Dogger Bank South Offshore Wind Farm

Appendix B4 to the Natural England Deadline 4 Submission
Natural England's comments and updated advice on Marine Physical Environment

Planning Inspectorate Reference EN010125

25th April 2025

Title:
Location and Indicative sediment transport pathways across Smithic Bank derived from bedform geometry

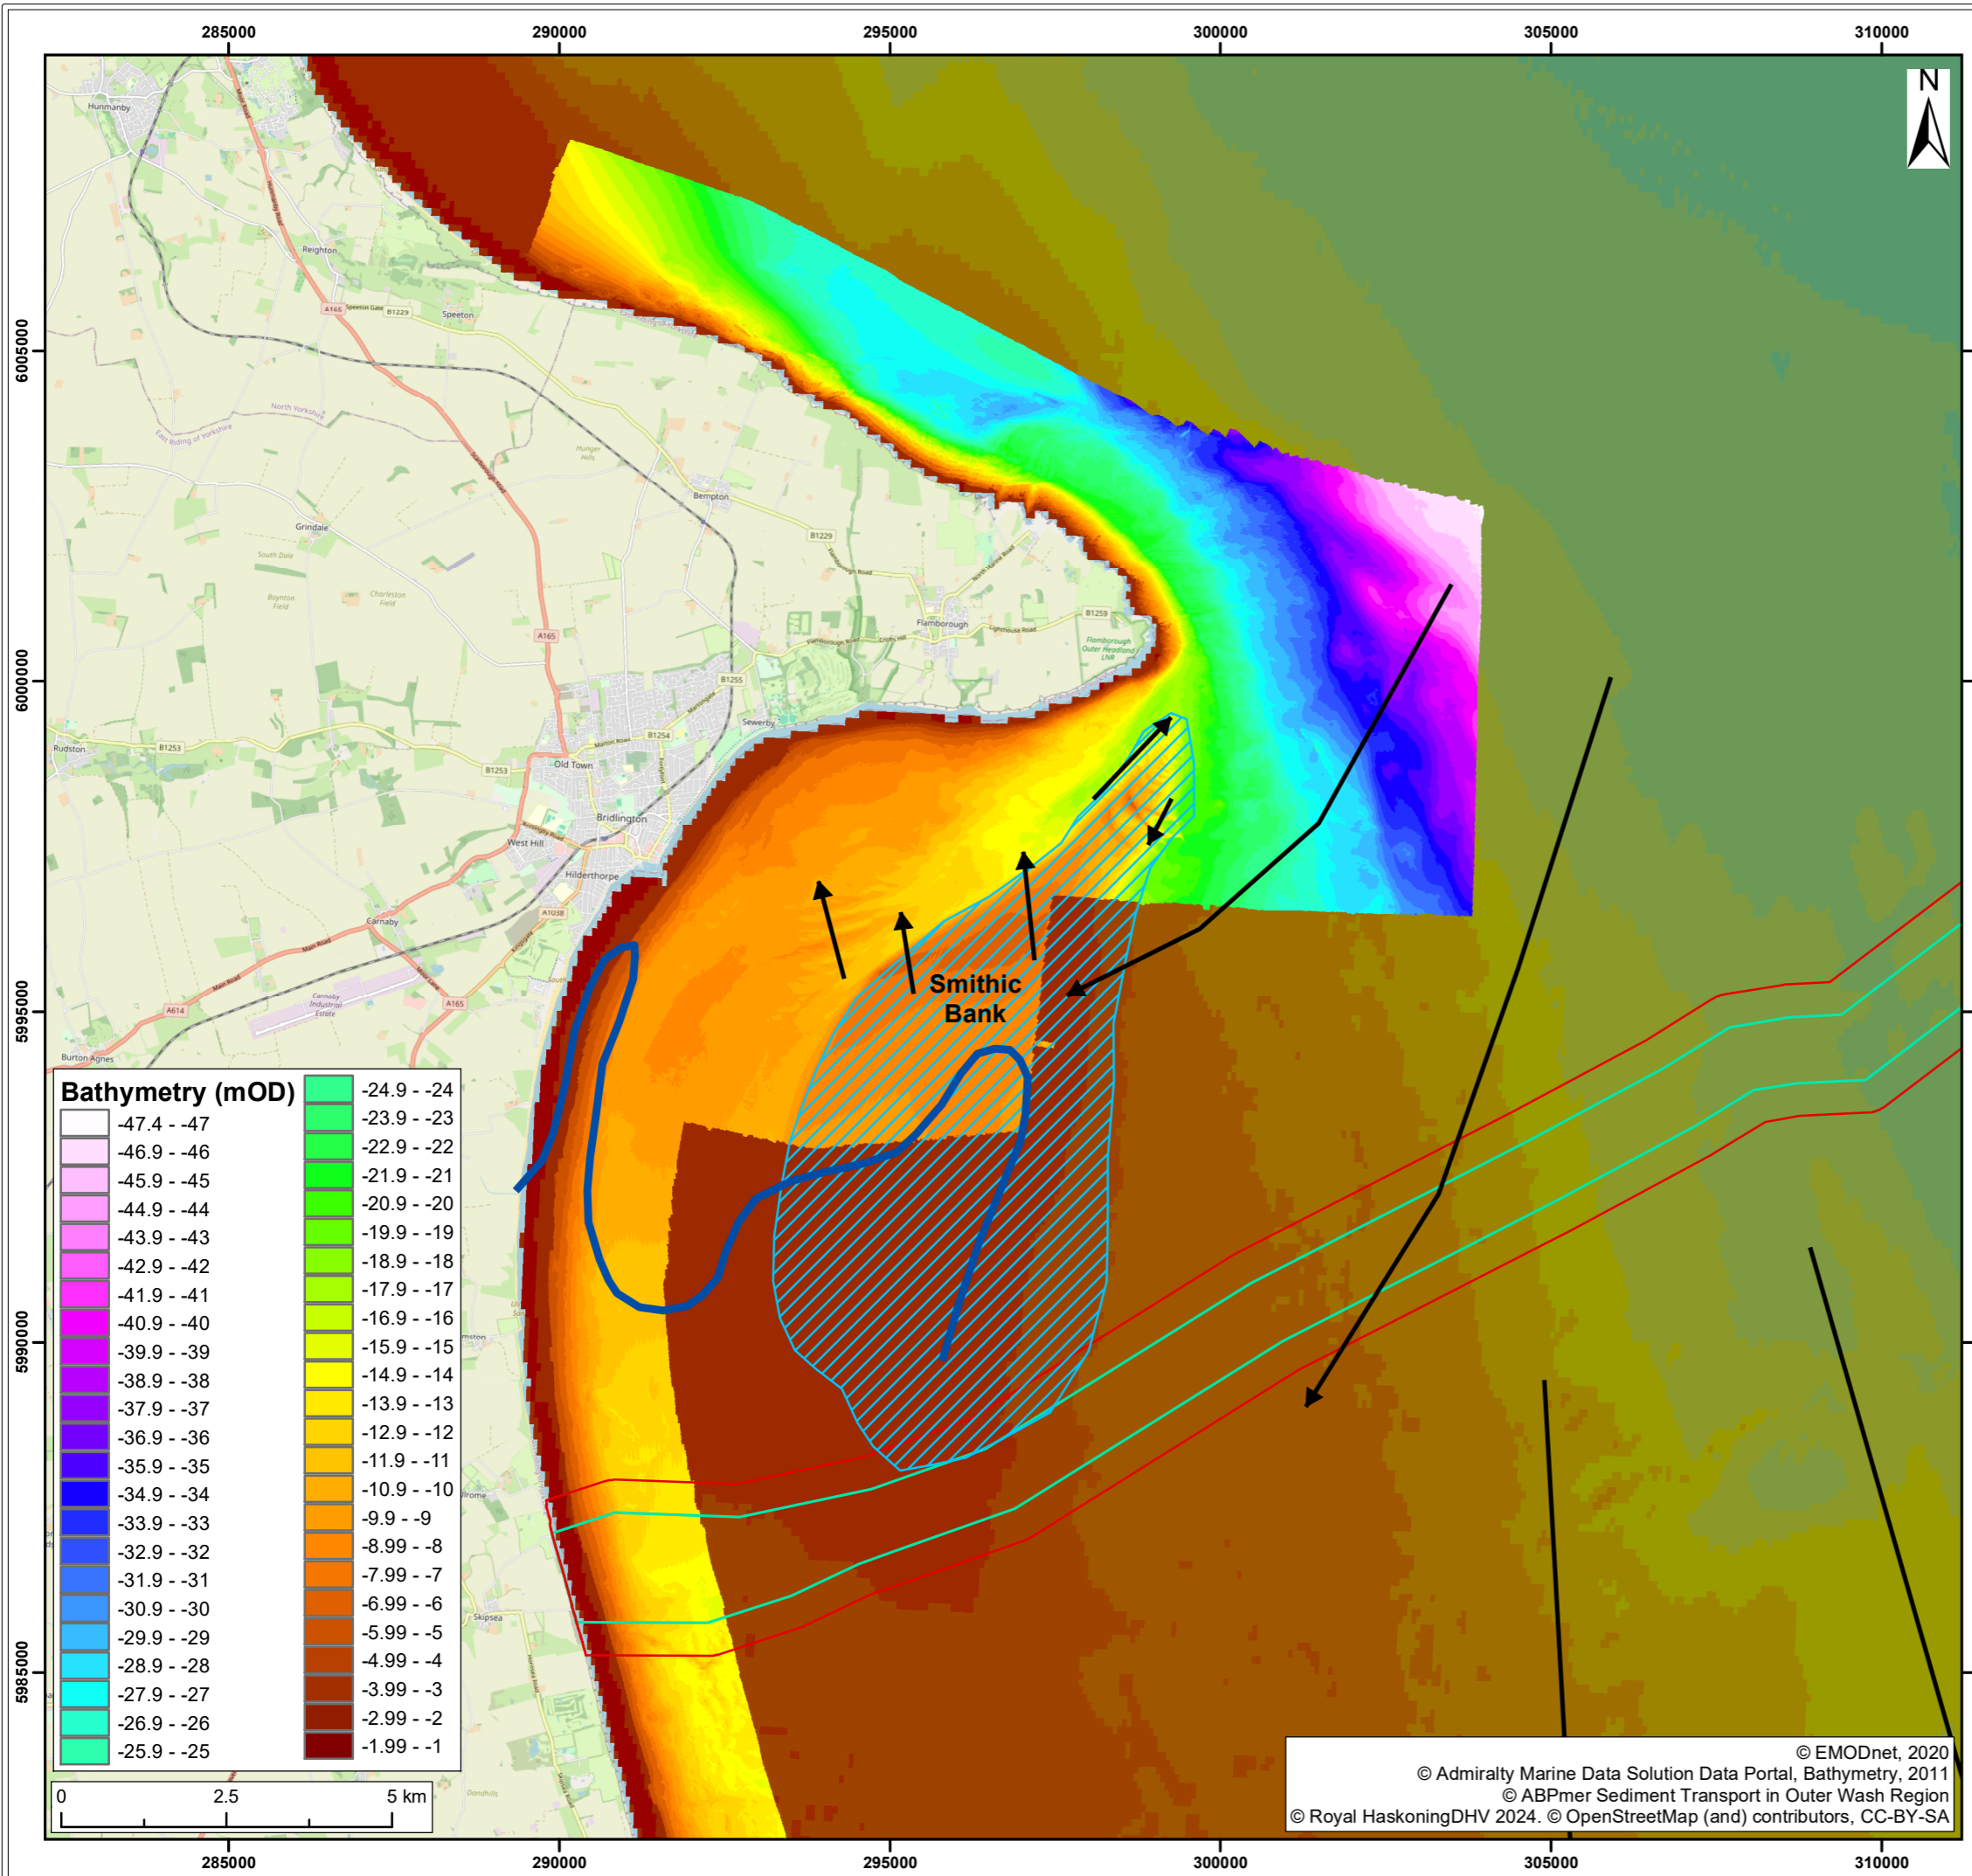
NE Ref	Section	Key Concern and/or Update	Natural England's Advice to Resolve Issue
1	General comment	Natural England welcomes the Bed Mobility & Thermal Environment report [REP3-032]. However, we note that this report pre-dates the ES (2024), including a review of all selected and deselected export cable route options. We also note that it includes the MarineSpace (2023) DBS background review of bed mobility which was used to support the ES Chapter 8 Marine Physical Environment [APP-080]. There does not appear to be any new information in this report that changes our current advice. Furthermore, we note that this report is due to be superseded.	Whilst Natural England welcomes this background review, the information doesn't change our current advice.
2	5.3.1	We note the conclusion drawn in [REP3-032] regarding cable burial risk within the arrays. This states that the <i>"sorted bedforms prevalent on Dogger Bank and covering large sections of the DBS OWF footprint are the primary sources of bed level change and this will need to be considered fully in the design of the inter-array cables and the latter sections of the export cable."</i> This aligns with concerns raised in our	<p>Natural England reiterates our previous advice that, at present, the potential for seabed mobility, cable exposure, and scour require further investigation, particularly on Dogger Bank and the latter two thirds of the offshore export cable corridor, and the nearshore.</p> <p>With regards to the assessment of seabed mobility and sediment transport pathways and rates, we advise that whilst observations of seabed morphological features may</p>

NE Ref	Section	Key Concern and/or Update	Natural England's Advice to Resolve Issue
		Relevant Representation and Risk and Issues Log [R&I, B29], that currently we do not have sufficient information to support the assessment conclusions regarding changes to bedload sediment transport and seabed morphology due to the presence of cable protection measures on Dogger Bank. We also advised that a seabed mobility assessment will need to be carried out to inform the cable burial assessment and, thus, requirement for surface laid cable protection on Dogger Bank. In [REP3-028], it is stated that as further site investigation and design work is due to be completed prior to construction, [REP3-032] this will be superseded, however an update to this or the Cable Burial Risk Assessment will not be provided within Examination timeframes.	be indicative of seabed mobility, the relative importance of tides and waves will need further consideration. We also advise that acquisition of further high-resolution site-specific bathymetric data would allow more accurate and confident assessment of bedform migration (direction and rate). Furthermore, the future effects of climate change and increased storminess will need to be considered over the lifetime of the project(s). [R&I, B29]
